WYCOB PTY LTD ACN 002 077 732
PO BOX 305 SWANSEA 2281
PH 0408 763 808
16 DECEMBER 2016

RE: PROPOSED DEVELOPMENT
STATE SIGNIFICANT DEVELOPMENT SSD 6518
FRAZER PARK QUARRY Lots 1 & 2 DP 549905 and Lot 465 DP 75526
800-900 Pacific Hwy Moonee.

Front Gate Schematic

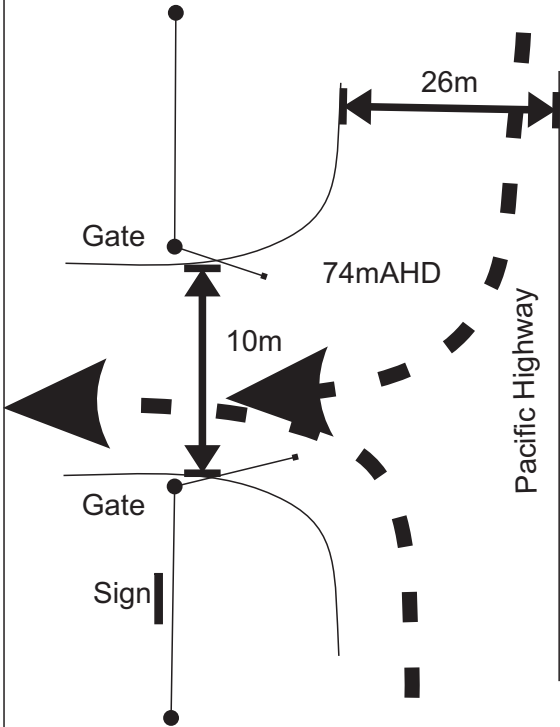
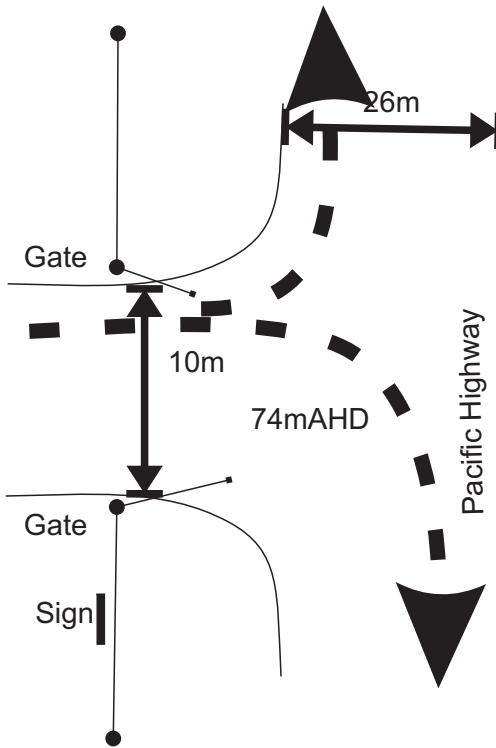
It states in the EIS (page 45 of 179) and Traffic Impact Assessment (Appendix 8) that right hand turns out of the quarry (northbound) will be restricted. The documents do not advise the route any vehicle wishing to travel north will use to effect a U turn. Both Kanangra Drive and Blue Wren Drive are not designed to accommodate turning vehicles of this length.

Q4b. Will “no right hand turn” signs be installed by the Roads and Maritime Services at the site’s entry to the Pacific Hwy?

Q4c. Where does the proponent intend northbound vehicles to U turn?

Our company has strong concerns that the empty vehicles will use the entry road into our property to conduct U turns. This road entry was designed by the then Department of Main Roads for our quarrying activities. Wycob was required to make a financial contribution for the construction of the road under our development consent approved in 1983. Since that time a right hand turning lane from the highway into Blue Wren Drive has been removed. This has resulted in an increase in the general public using our entry to U turn to head south to enter the National Park at times impeding the egress of our vehicles from our property. Our road entry was not designed for B double vehicles to conduct U turns in front of our ingress/egress lanes for the benefit of the development up the road.
